8 February 2022

Macquarie Data Centre IC3 State Significant Development: Response to City of Ryde Council Submission

The purpose of this letter is to respond to a submission made by the City of Ryde Council (Council) on the Biodiversity Development Assessment Report waiver request prepared by Cumberland Ecology (ref. 21116 – Let2, dated 19 August 2021) to support the State Significant Development of the Macquarie Data Centre IC3 located at 17-23 Talavera Road, Macquarie Park (the 'site'). Council's submission is provided below in italics, followed by our response.

Trees to be retained inside site boundary: 29
 Trees to be removed inside site boundary: 55

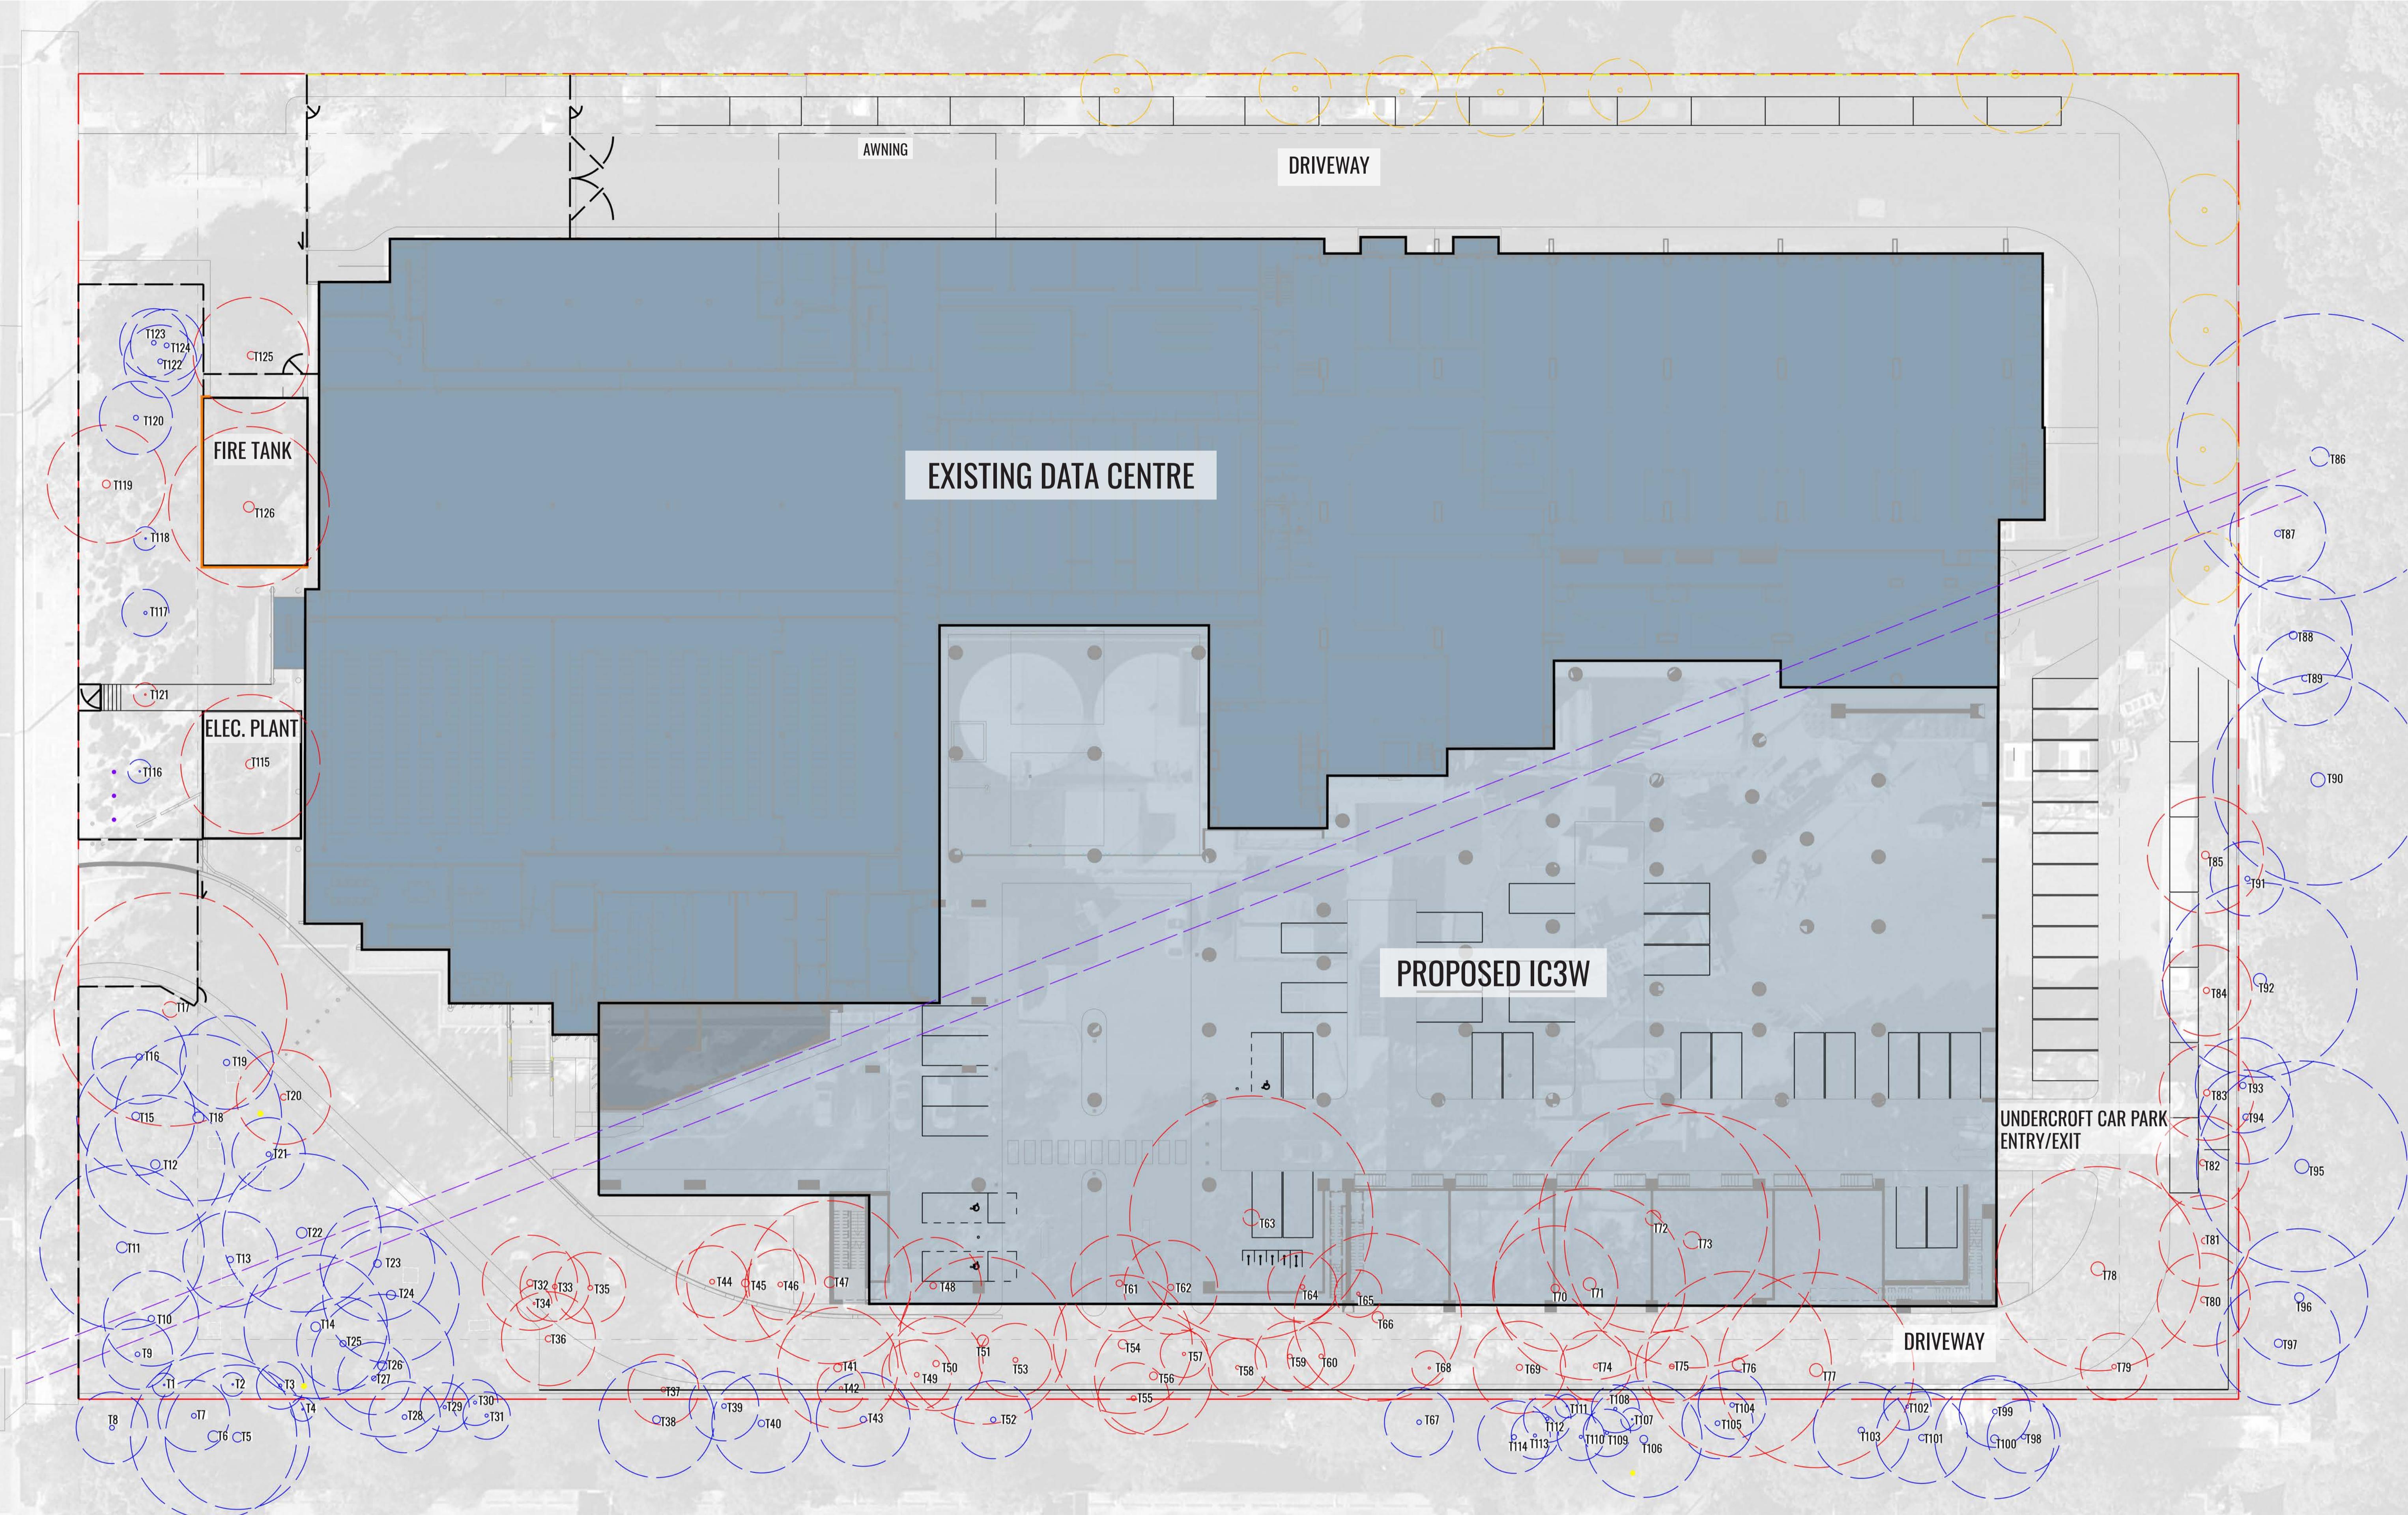
Of particular note is the removal of Trees 36, 45, 47, 51, 54, 56, 62, 66, 71, 76, 77, 78, 119 & 121 which are of a species consistent with those listed under two Critically Endangered Ecological Communities (CEEC), being Blue Gum High Forest in the Sydney Basin Bioregion (BGHF) and Sydney-Turpentine-Ironbark Forest in the Sydney Basin Bioregion (STIF). Although the documentation provided asserts that site vegetation is likely to have been planted following land clearing works undertaken prior to 1943, it remains unclear what ecological value this planted, but well-established, CEEC vegetation holds.

Review of historical aerial imagery via the NSW Government 'Spatial Portal' shows that by 1943 the site was nearly completely cleared for agriculture, though some vegetation may have remained along the north-western boundary of the site. By 1971 all vegetation across the site had been cleared, and some of the current plantings appear to have been undertaken in the intervening period between then and 1986, in neat lines surrounding hard stand car parking areas. As the entire site has been cleared of historical vegetation which may have originally comprised either the BGHF or the STIF threatened ecological communities (TECs), there are no current ecological values present on the site pertaining to a remnant or regrowth occurrence of either TEC.

Some tree species are present which would naturally occur in either TEC, such as *Eucalyptus saligna* (Sydney Blue Gum) and *Angophora costata* (Smooth-barked Apple); however, these species have been planted for landscaping purposes in a matrix including non-indigenous native and exotic species. As such, there is no similarity between this landscaped vegetation and a natural occurrence of either TEC beyond that the vegetation contains some species that could occur in either TEC. However, the individuals of these species are of unknown provenance, and are likely to have been sourced from mass nursery stock which has the potential to either be of non-local provenance, or potentially from inbred nursery stock which may have an accumulation of deleterious recessive alleles. These trees are therefore unlikely to contribute to the retention of local genetic diversity of the species and have no ecological value beyond foraging habitat for local fauna species.

While the final determination for BGHF and STIF mention the community can persist as remnant trees over an exotic understorey, the value of these trees is described only in terms of ecological significance due to being persistent remnant trees, and as a source of genetic material to be used in rehabilitation plantings. Neither final determination states that planted trees of characteristic species (even if undertaken for revegetation versus landscaping purposes) conform to the listed communities. As the trees are landscape plantings, and not intentional revegetation plantings, and furthermore were from a time before provenance of plants in revegetation projects was considered important, the trees are very unlikely to contain local genetic diversity or have any particular ecological significance in terms of being associated with TECs. The ecological purpose they serve is therefore of no greater significance than any other garden plantings of native species. It is further noted that the species present within the site are commonly used in landscaping in Sydney and elsewhere in NSW.
